CITY OF ALBUQUERQUE

RE: **Church's Chicken #695** – 5407 Central Ave. NW
Grading and Drainage Plan for Building Permit

File **K11-D081**
PE Stamp: 8/26/13

Based upon the information provided in your submittal received 8/29/2013, the subject Grading and Drainage plan cannot be approved for Building Permit. The following comments need to be addressed prior to approval:

GRADING & DRAINAGE PLAN

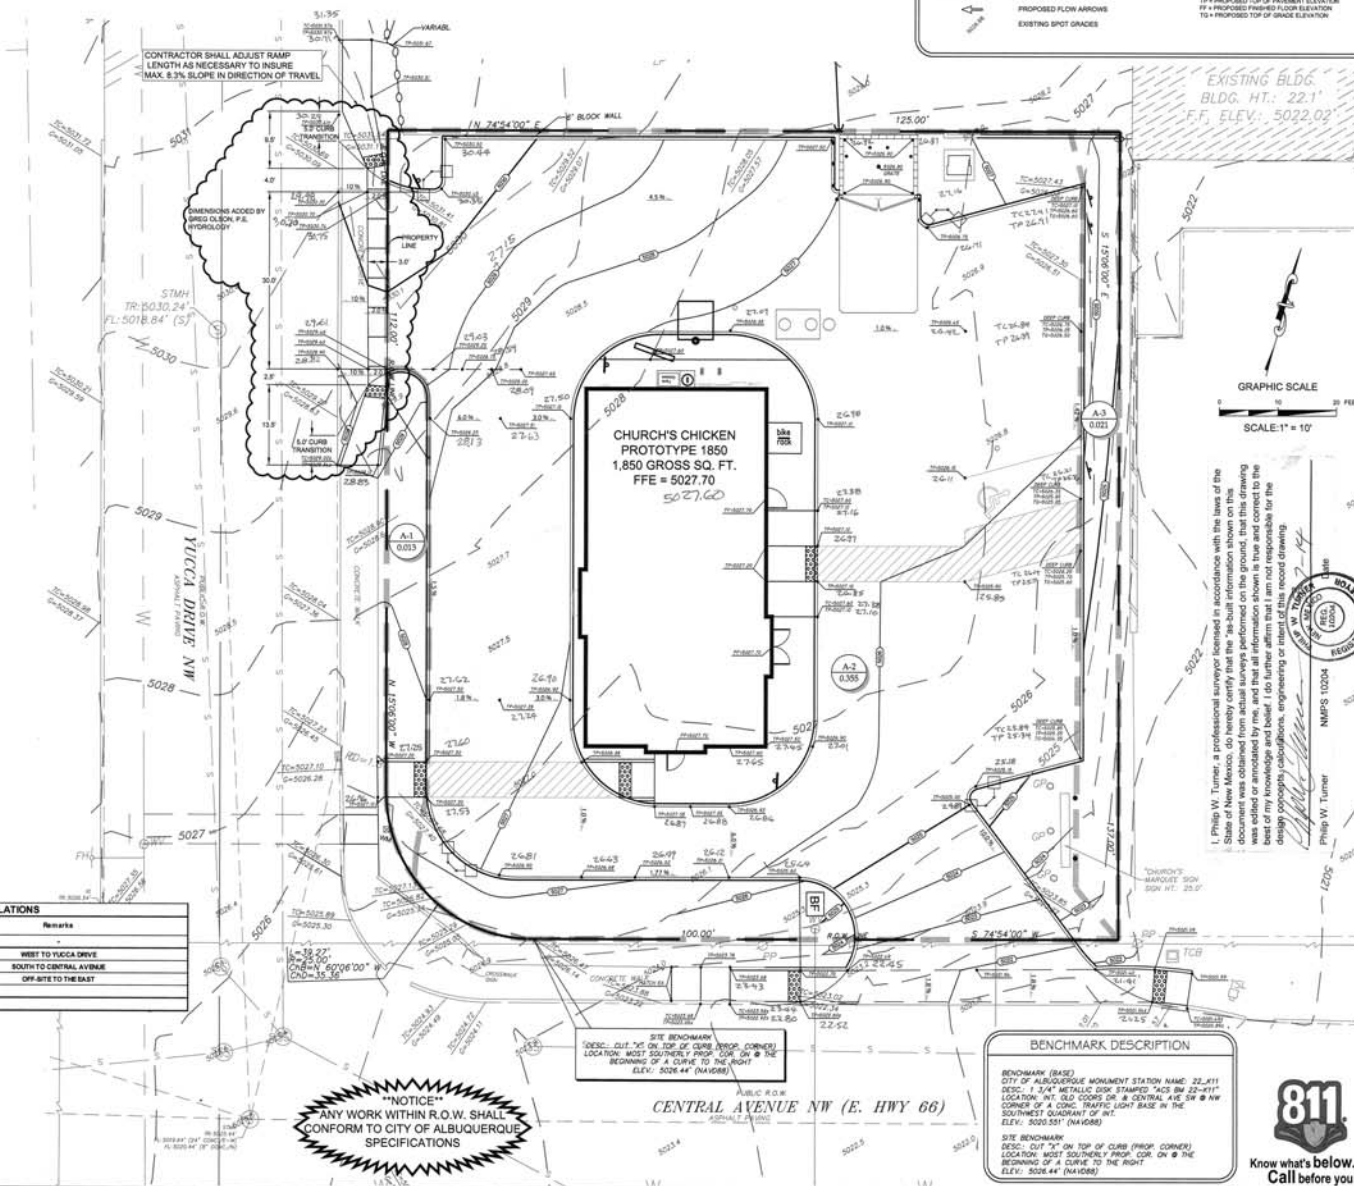
1. Wide Drainage Basin Boundary Lines used on this plan obscure some information critical to my review.
2. What is the "honey-comb" hatching in the area near the proposed dumpster?

3. Provide pad elevations at the dumpster pad showing drainage to the proposed floor drain, and provide reference to the drain, which is routed to a grease trap, as shown elsewhere on sheet ____.

4. In advance of our Drainage Ordinance amendment requiring it, Hydrology Section *encourages* water Harvesting features in Grading Plans, such as depressed parking islands and landscape areas. Is there any way for you to route some of the parking lot flow through depressed landscaping areas?

5. Clarify how the 5' drop on the east side of the lot is stabilized to prevent erosion.
6. The west driveway entrance must include a water block to prevent street flows on fYucca from entering the site. As we discussed by phone, please consider alternate entrance designs, such as COA Standard DWG 24225 or 2428.
